# Site Plan\_V1.pdf Markup Summary

A Site Plan
 SCALE: 1" = 20'-0"

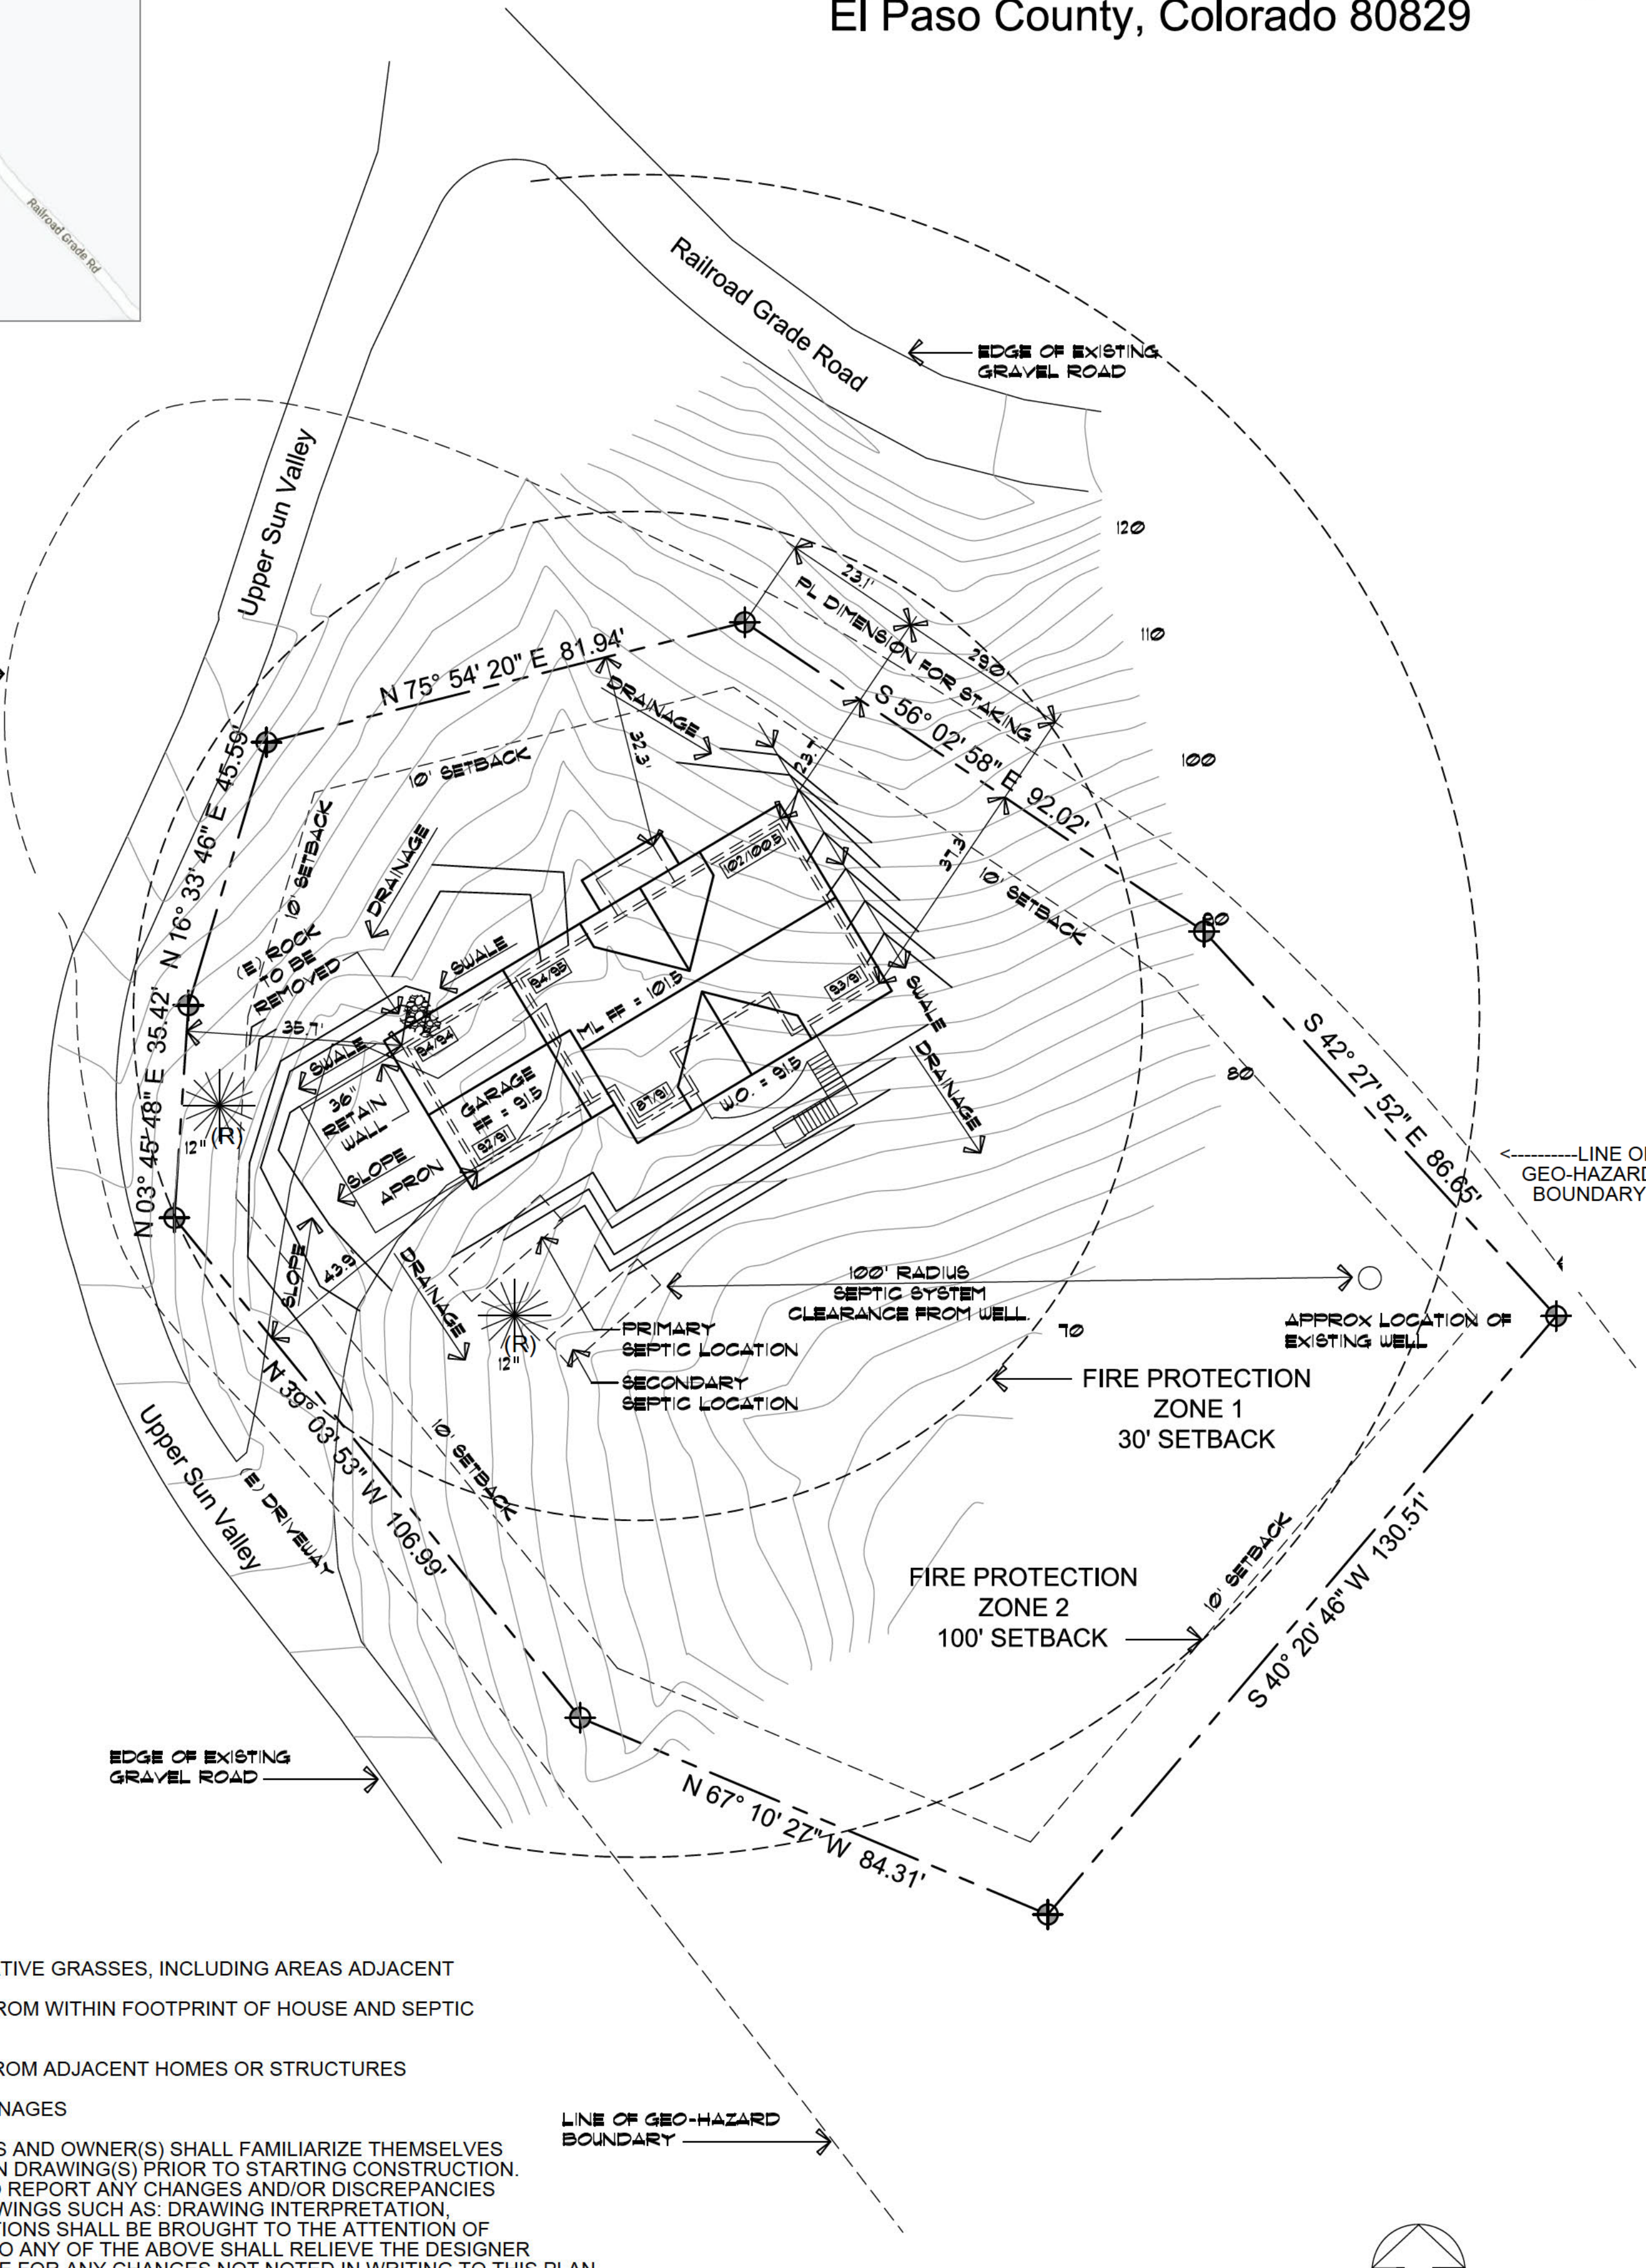
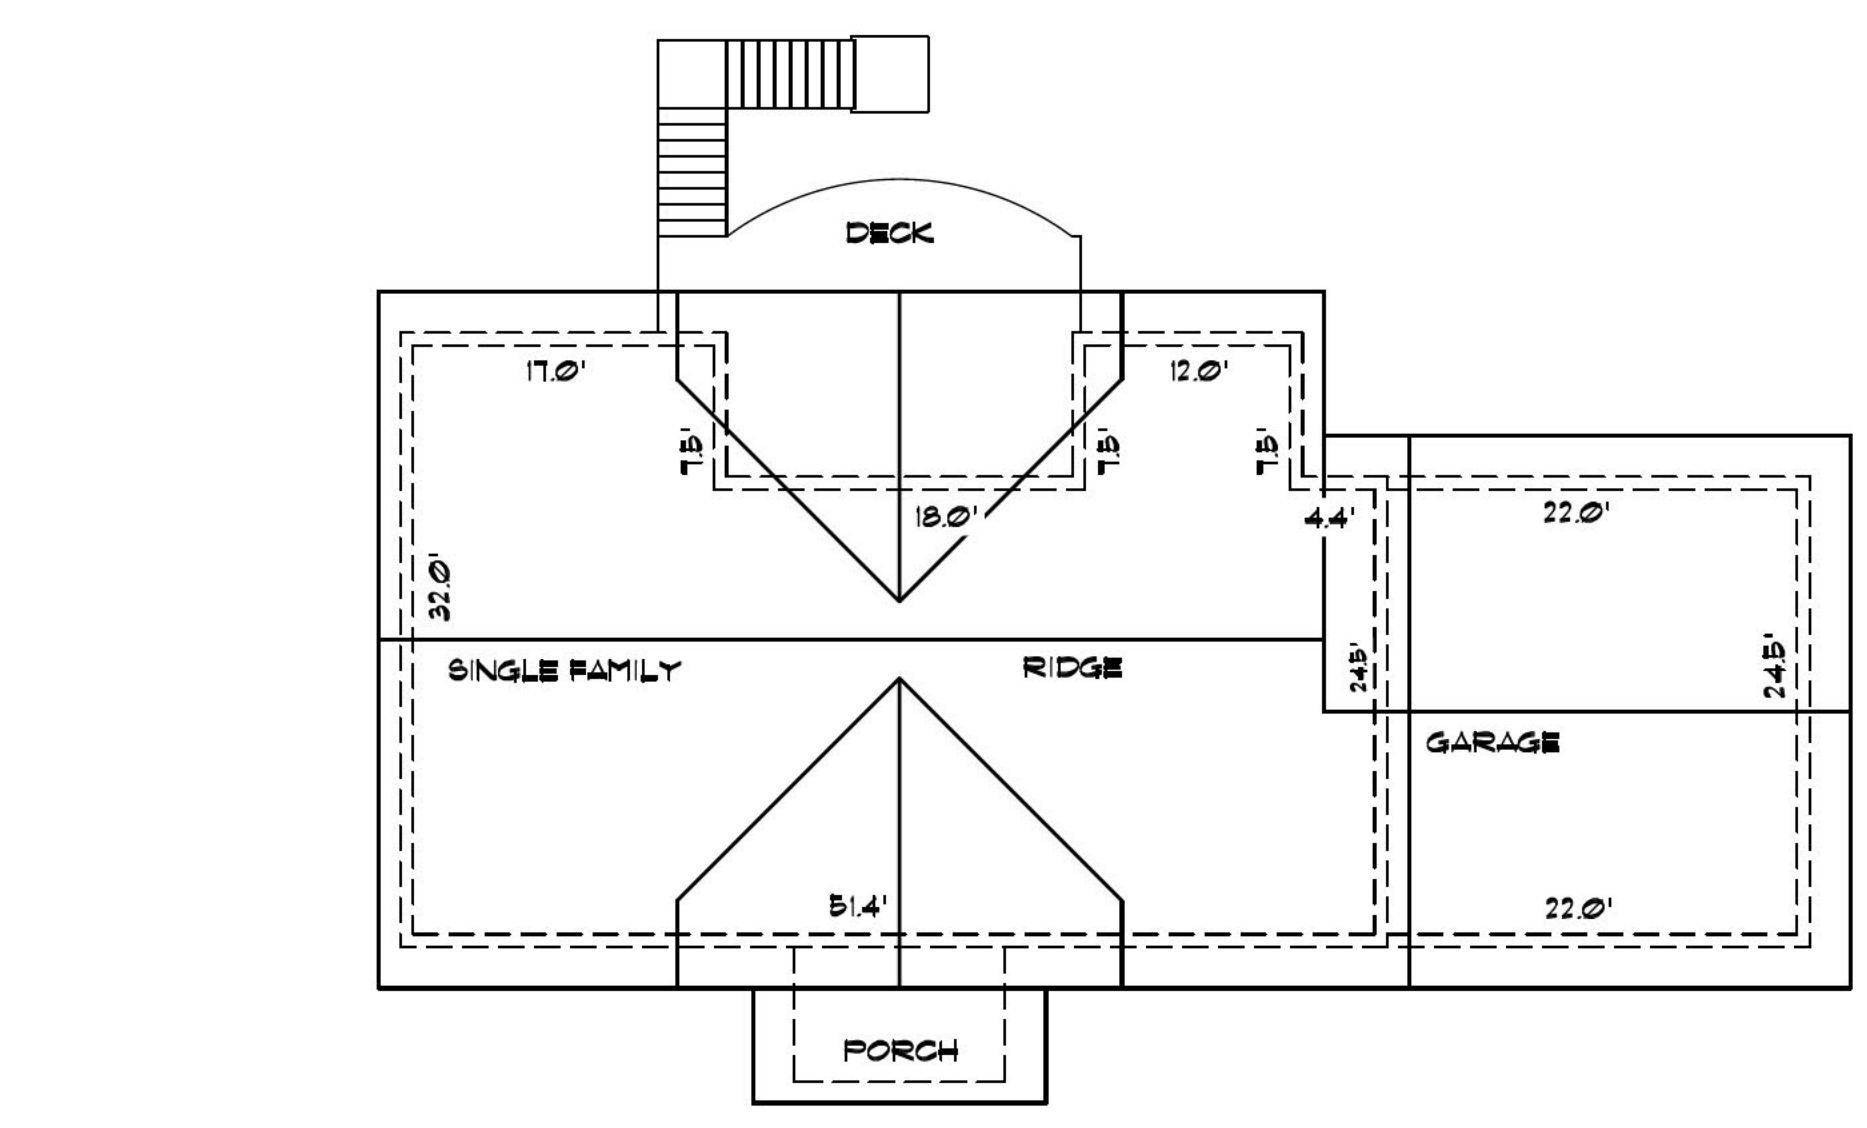
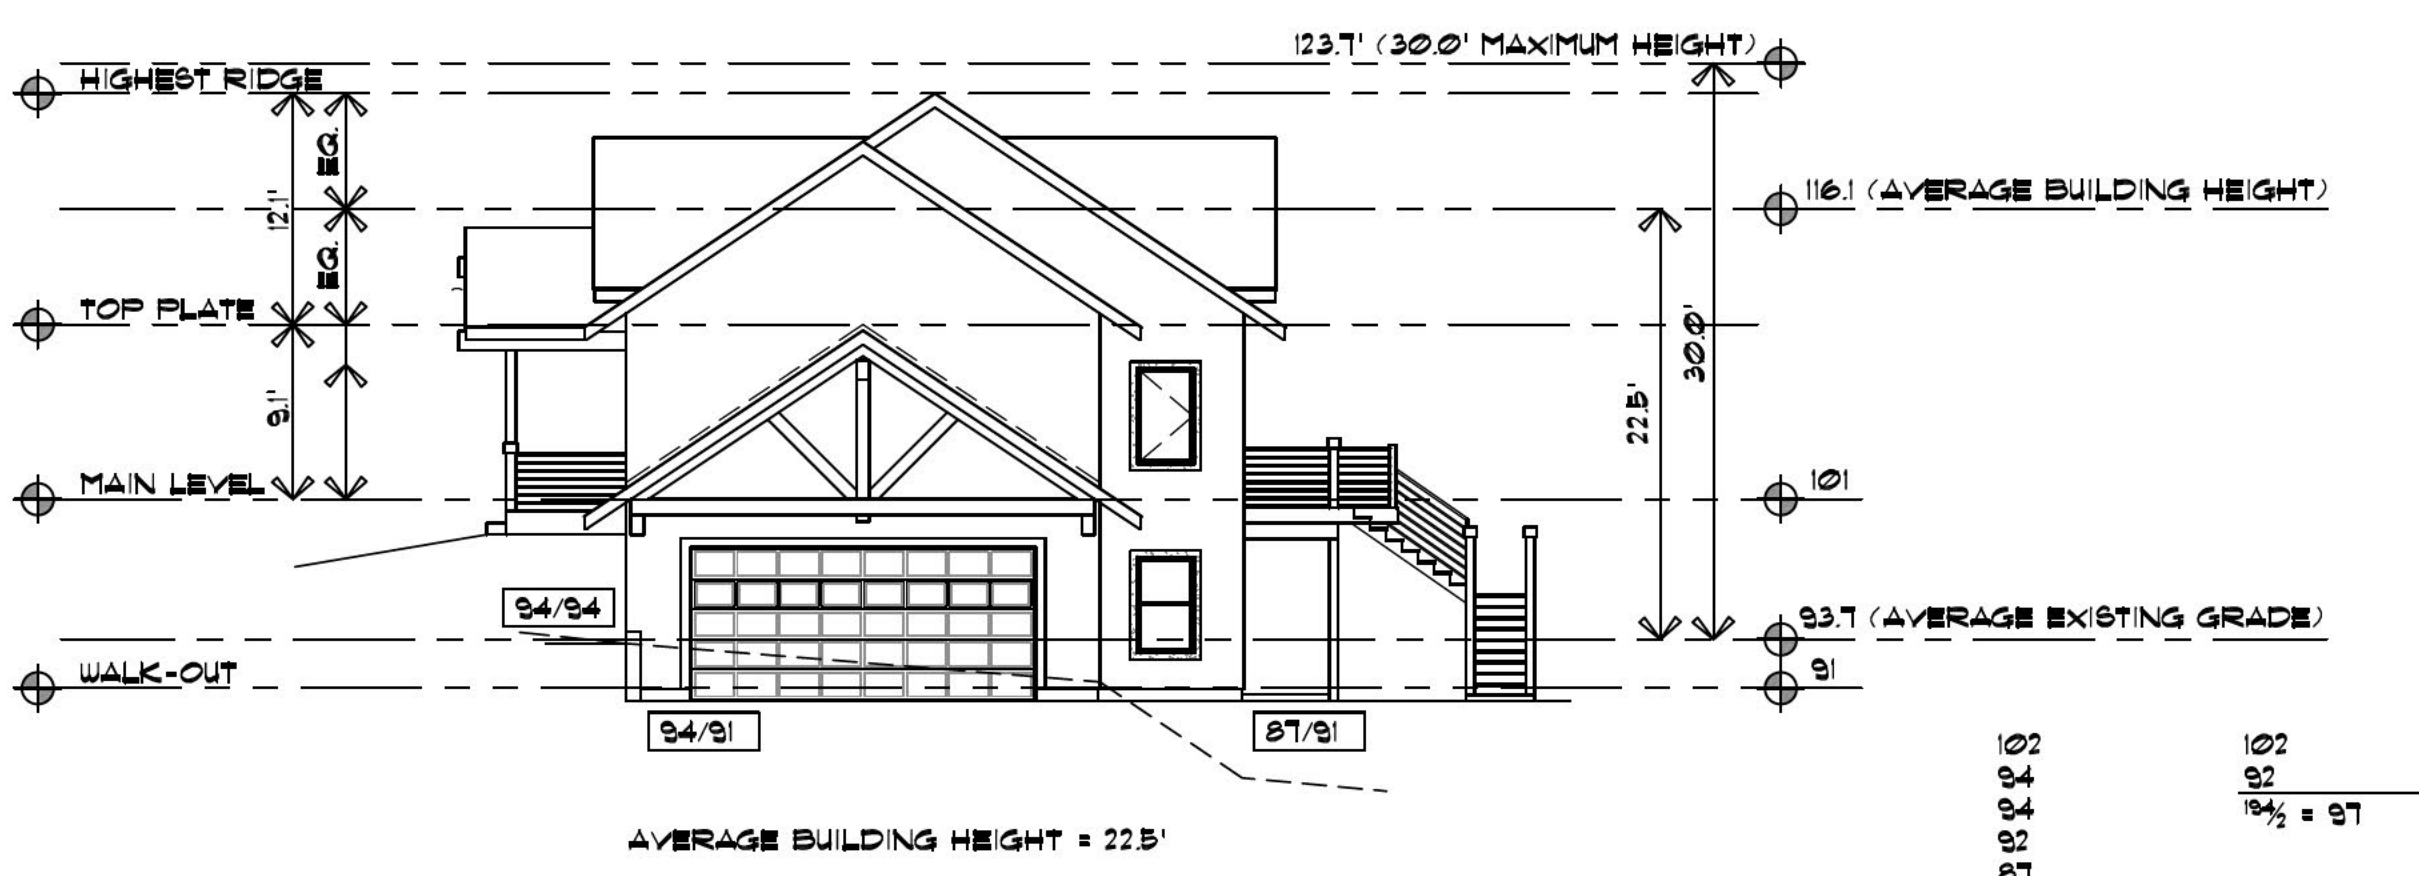
**Subject:** Easements  
**Page Label:** 1  
**Author:** Sophie Kiepe  
**Date:** 4/9/2021 11:36:05 AM  
**Status:**  
**Color:** ■  
**Layer:**  
**Space:**

Where is access to be taken from? Please  
show proposed driveway location and  
dimension.

Note: An access permit is required for any  
proposed driveway.

Where is access to be taken from? Please show  
proposed driveway location and dimension.

Note: An access permit is required for any  
proposed driveway.

Setback requirements per development guidelines  
are 100 feet distance between dwellings. Please  
denote the distance between the proposed  
structures and any structures within 300 feet.

Also, there shall be a minimum of 50 feet distance  
between proposed accessory structures over 120  
square feet and accessory structures over 120 SF  
on adjacent properties. Please denote this  
distance on the plan, if any.

No structure shall be closer than 25 feet from any  
drainage way, per the development regulations.  
Please denote measurements to confirm  
compliance with this requirement.

Landscaping/ information is required per  
Development Regulations:
